J.S. THOMPSON
ENGINEERING, INC

June 22, 2020

The structural plans were reviewed for 216 Bay Street in Harnett County, North Carolina to address three items. Analysis revealed the following:

SHEET 1 OF 3
S-1
FOUNDATION PLAN

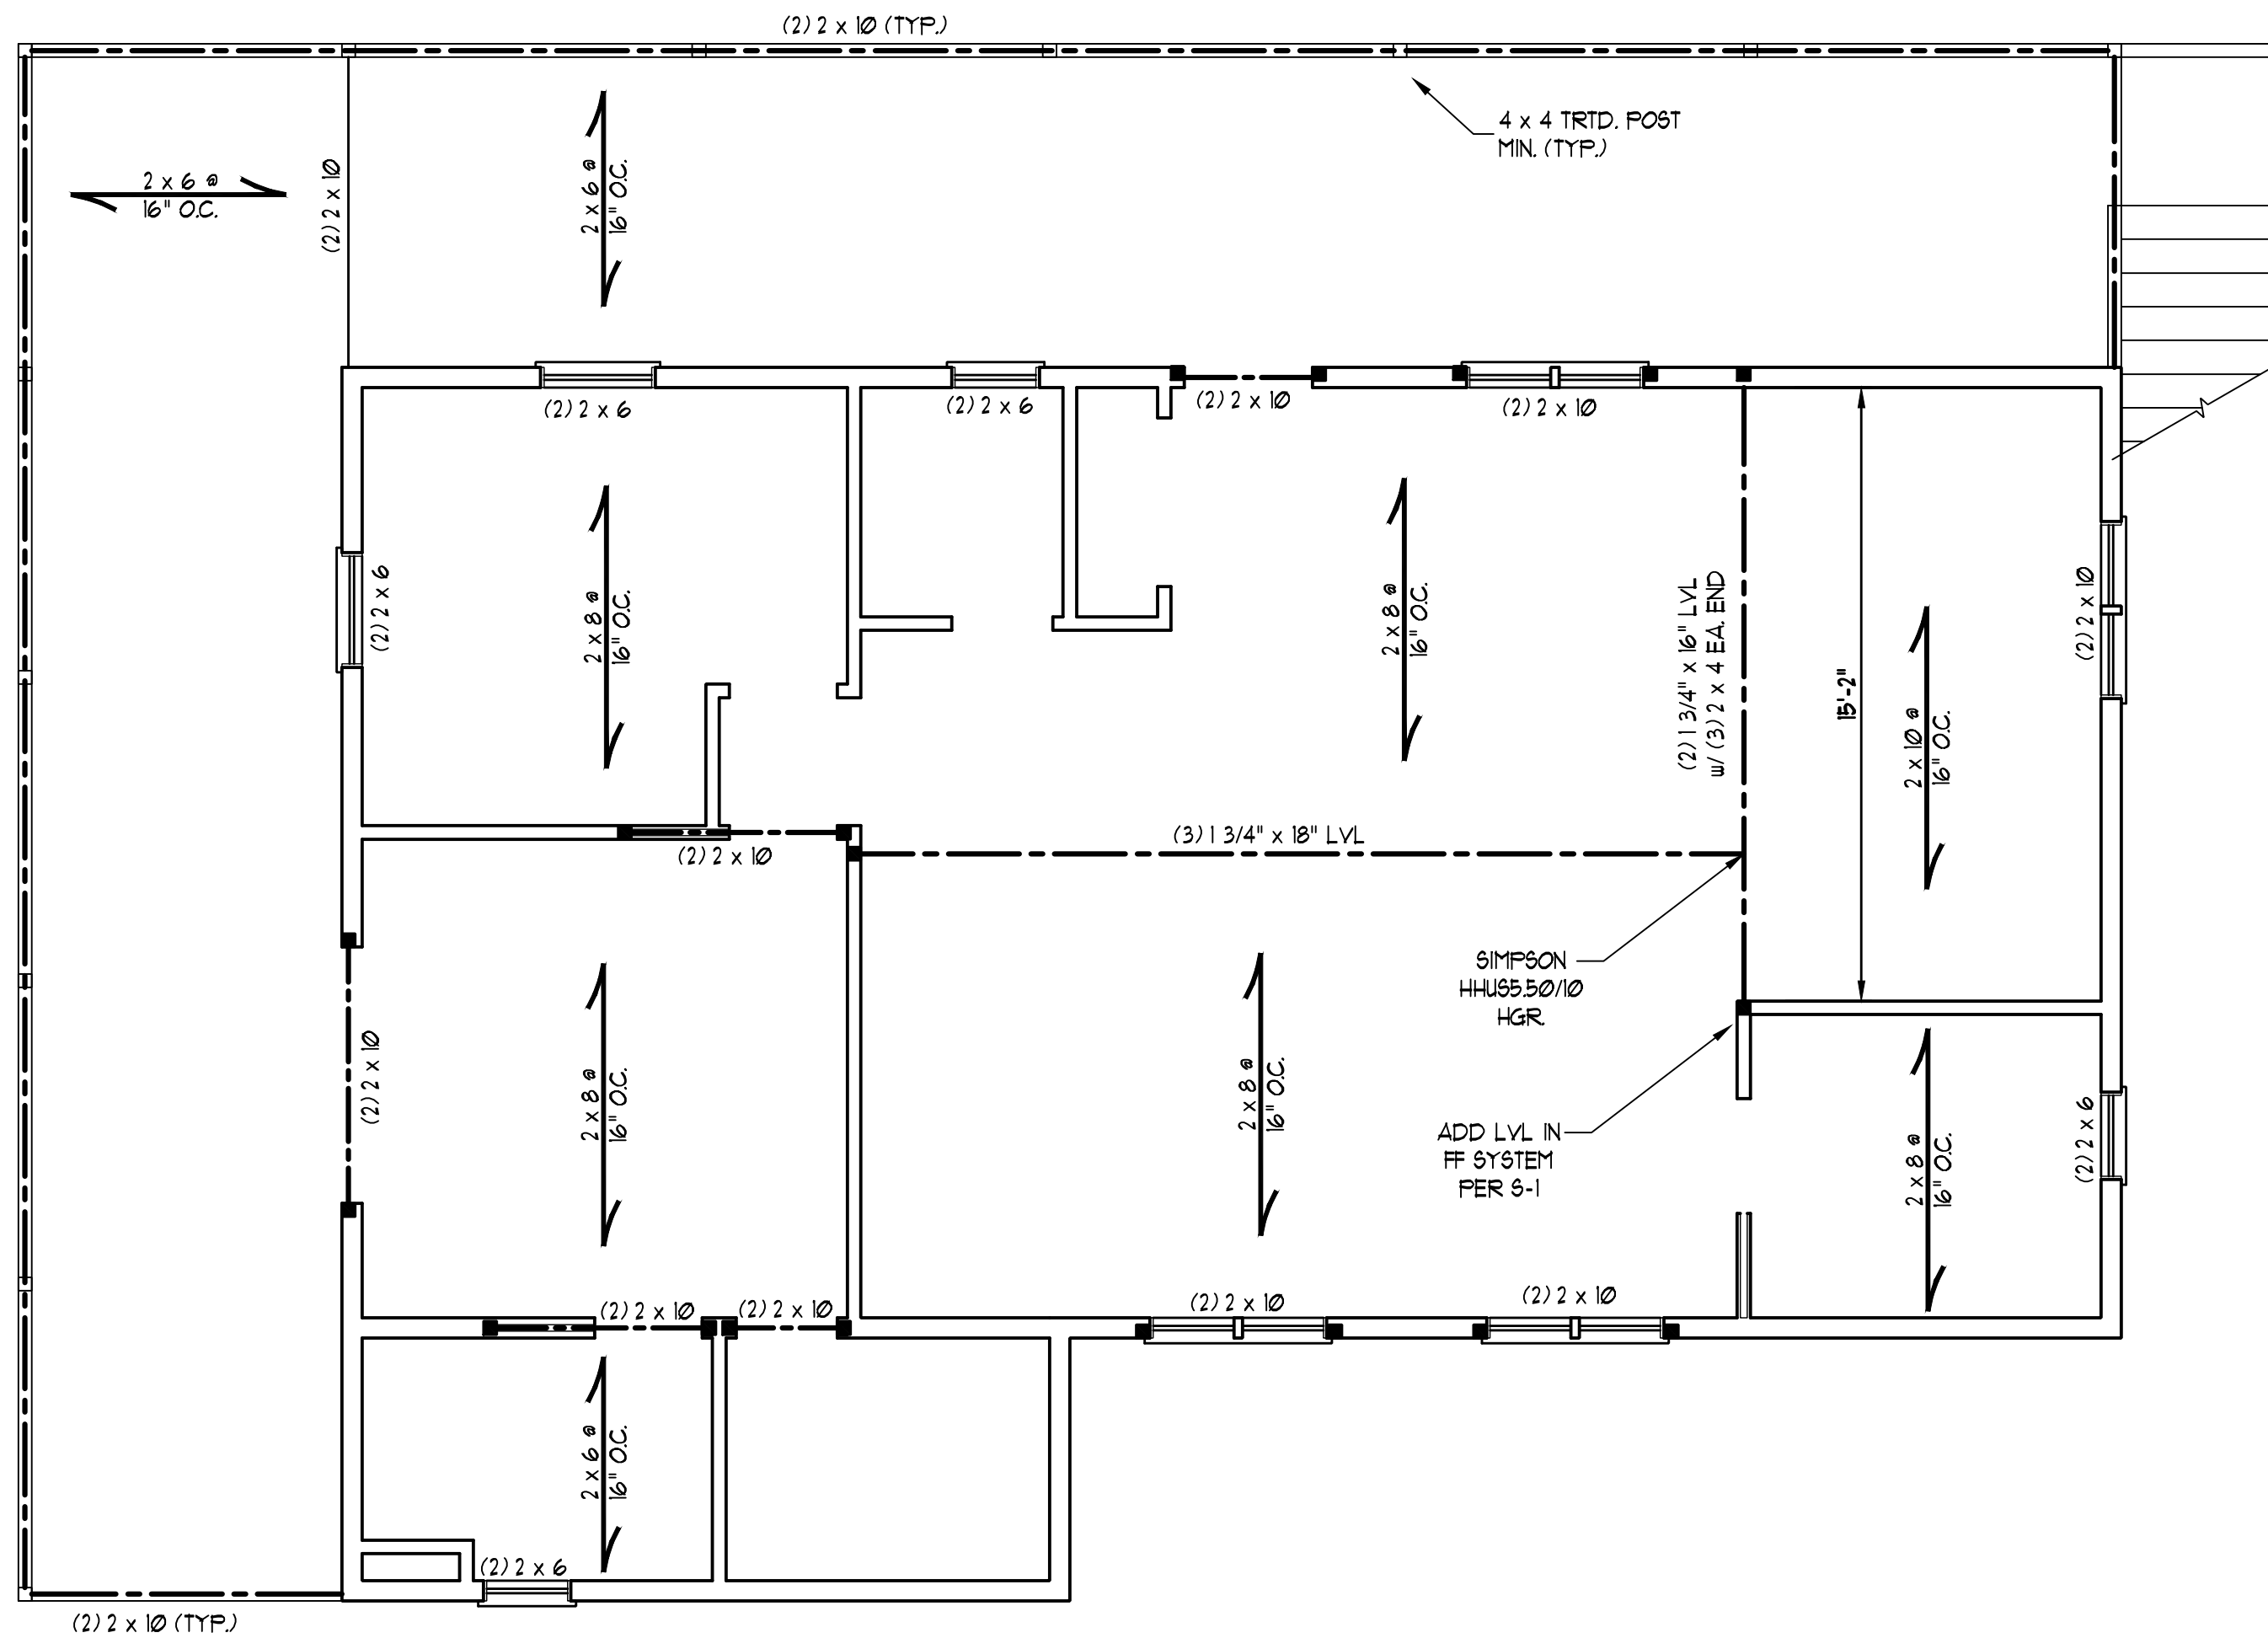
- 1) In lieu of through bolts, the porch band may be attached to the house with (2) rows of Simpson SDS (or equivalent) screws at 16" o.c.
- 2) In order to create a vaulted ceiling at the porch, the ceiling joists are not required to be installed.
- 3) The 6 x 6 treated posts were set on the poured concrete footings and (2) #4 x 24" rebar were installed through the bottom of the posts per our direction. Rebar dowels were embedded into the top of the footings and bent at an "L" across the rebar at the bottom of the posts to prevent uplift. The rebar was installed per our specifications. The footings are suitable for the second concrete pour.

This configuration will provide the required support for all applied loads.
